CITY OF ALBUQUERQUE

**RE: 9808 Central Ave.
Grading and Drainage Plan
Engineer's Stamp Date 3-4-2016 (File: L20D024)**

SHEET NO. C1

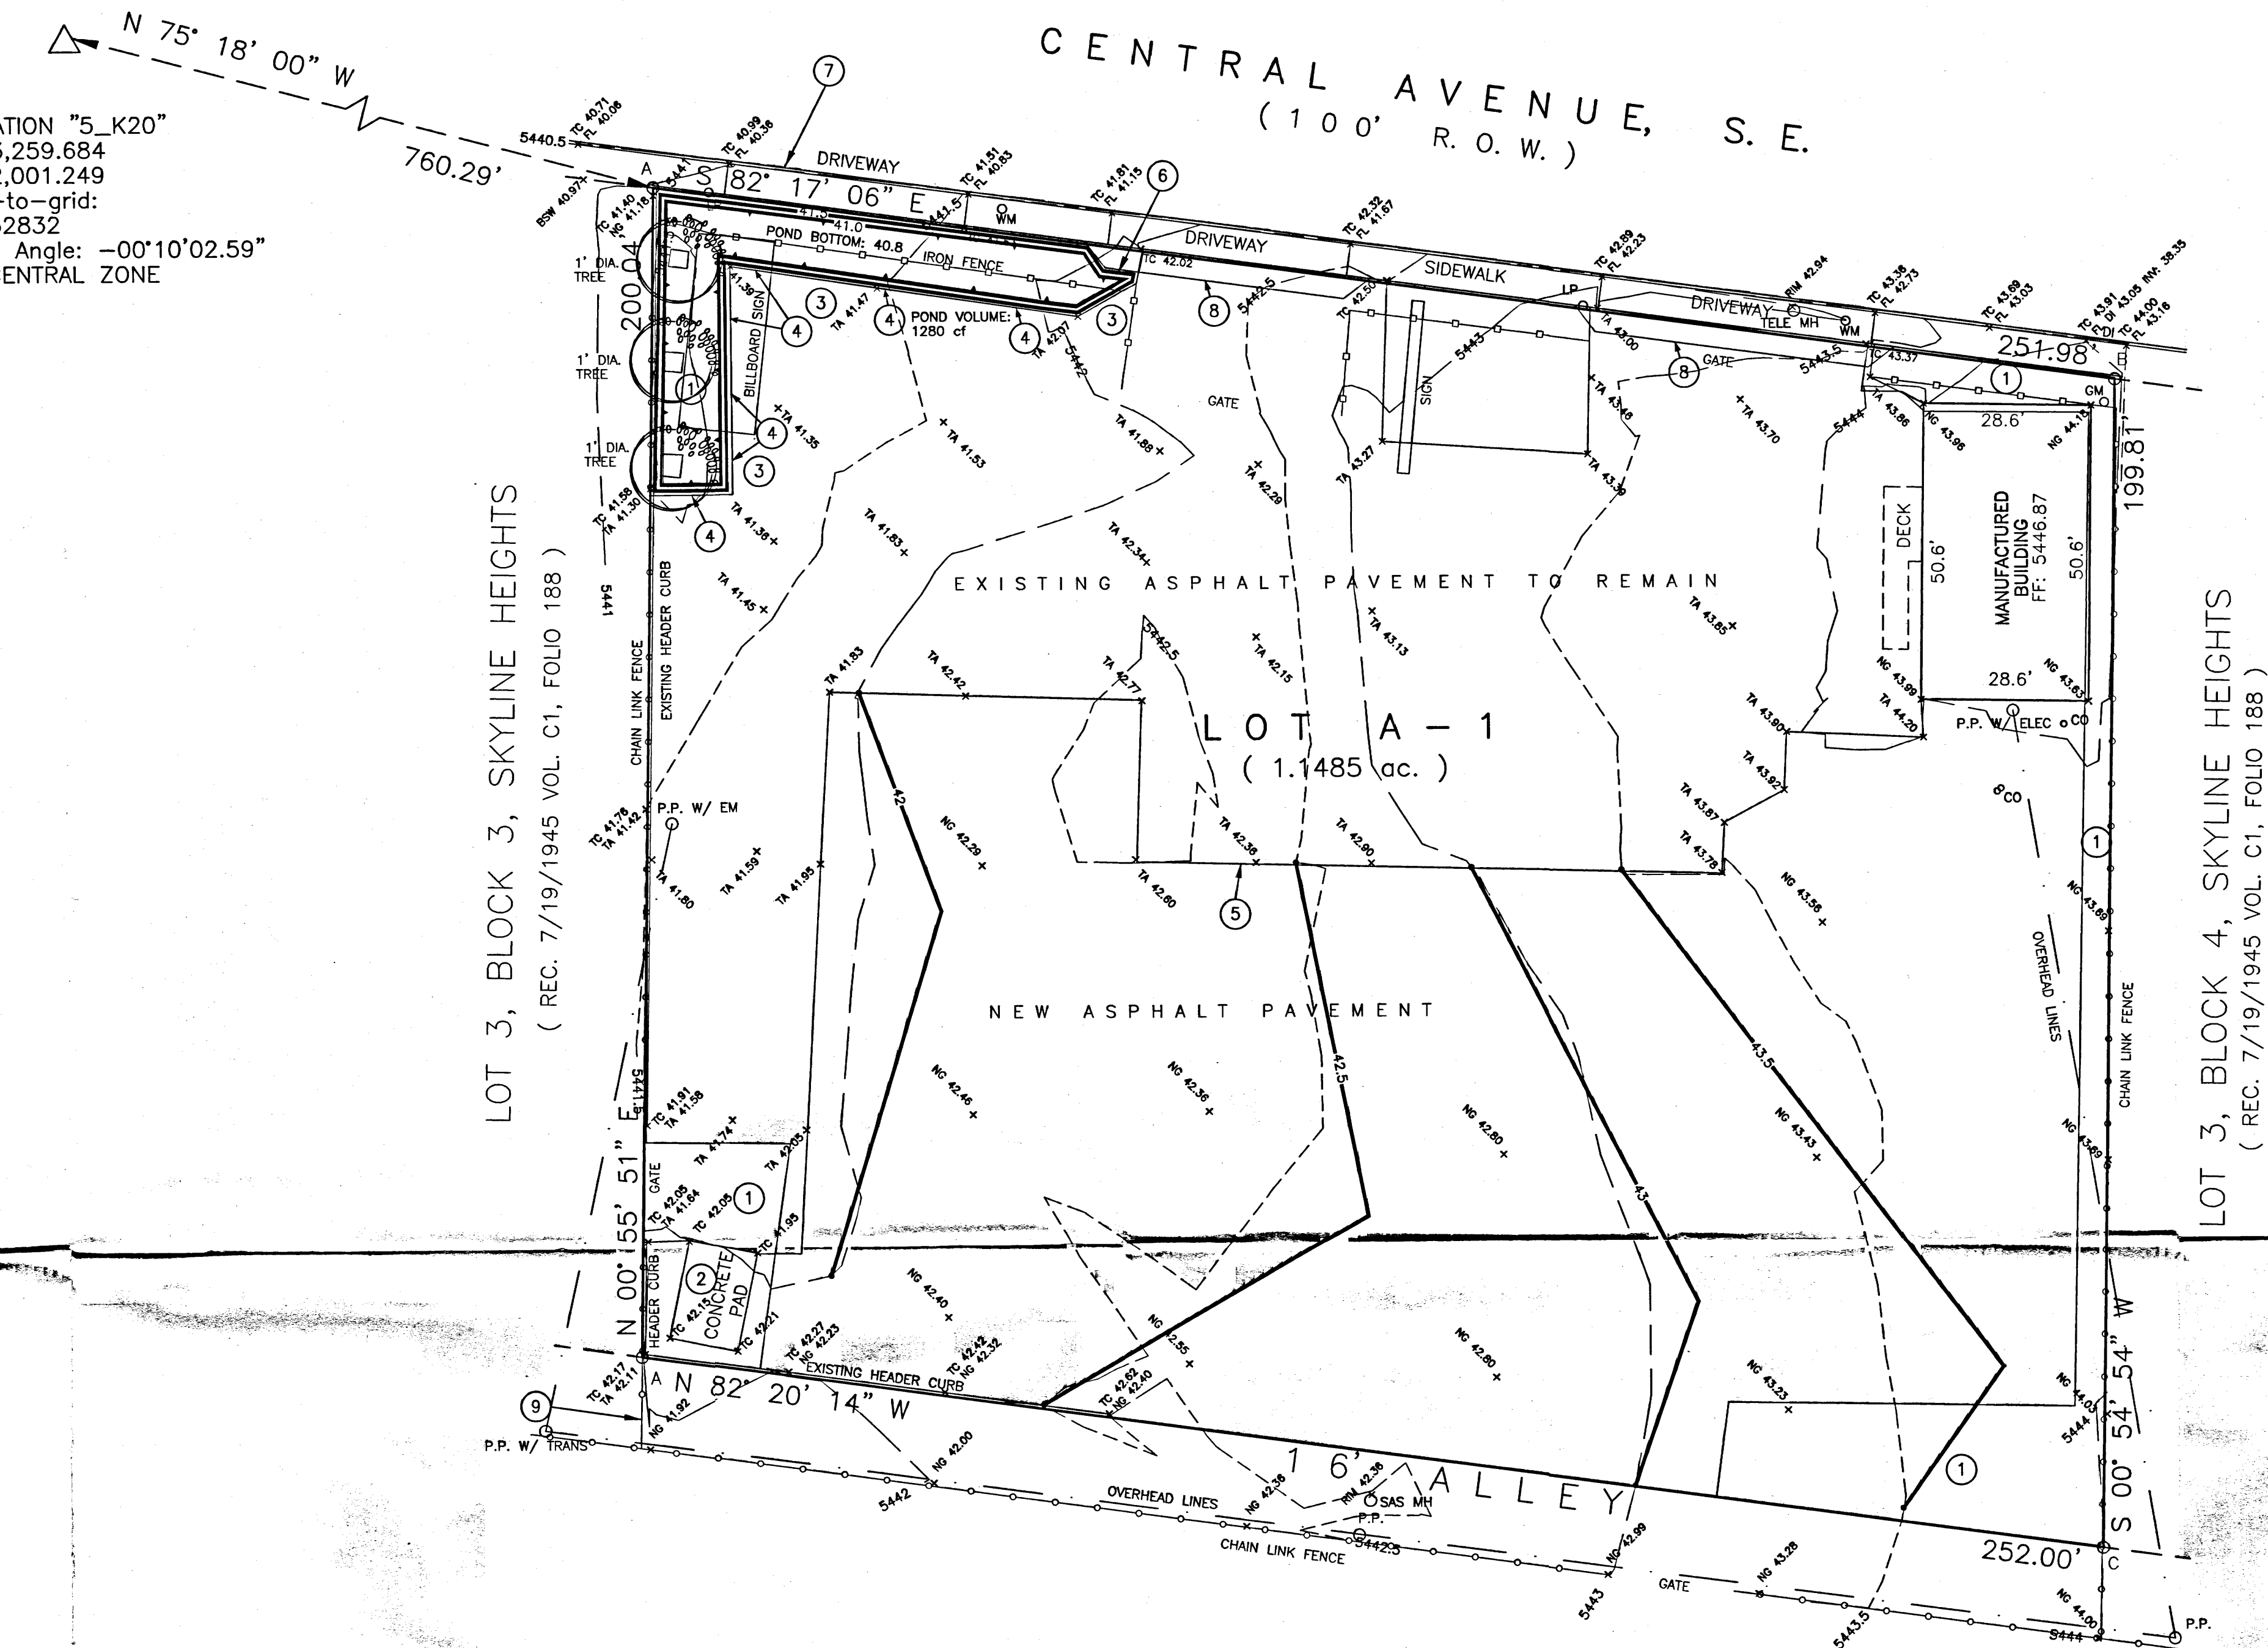
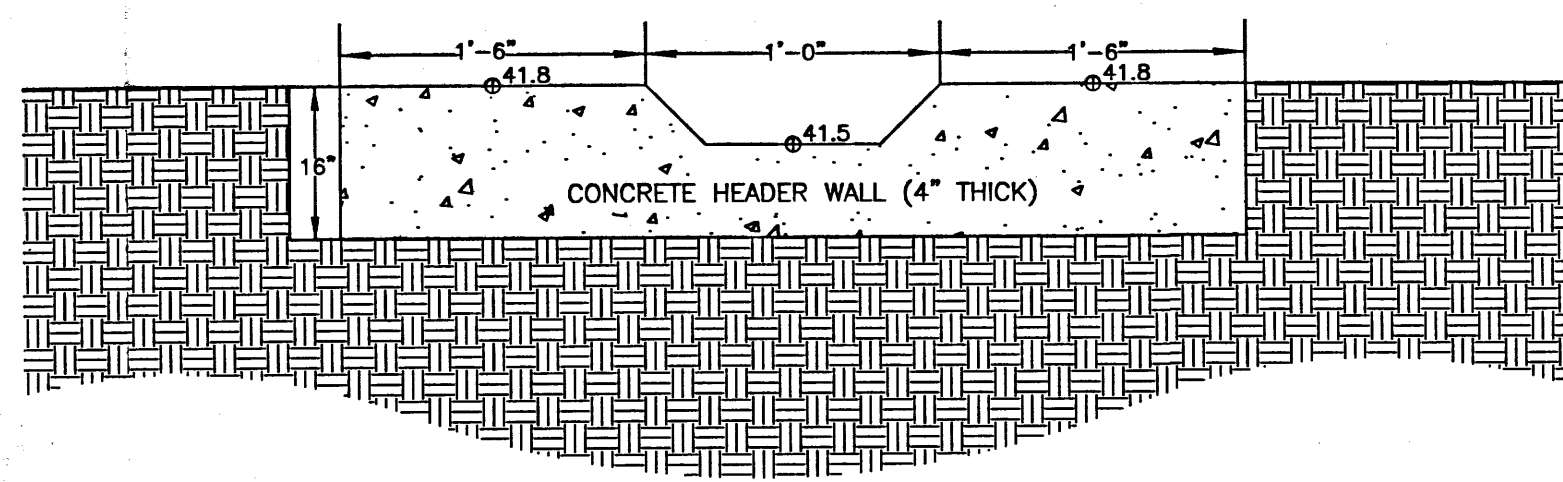
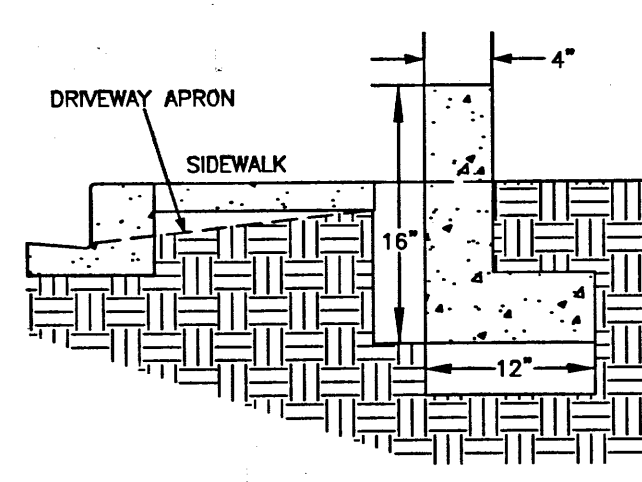
Based upon the information provided in your submittal received 3-4-2016, the above referenced Grading and Drainage Plan is approved for Grading Permit and Paving Permit. Our previous comment letter mentioned the need for a SO-19 Permit, but that was triggered by the sidewalk culvert which is no longer a part of the design, so it is no longer needed. No need to resubmit, you may just cross out the note that references the permit.
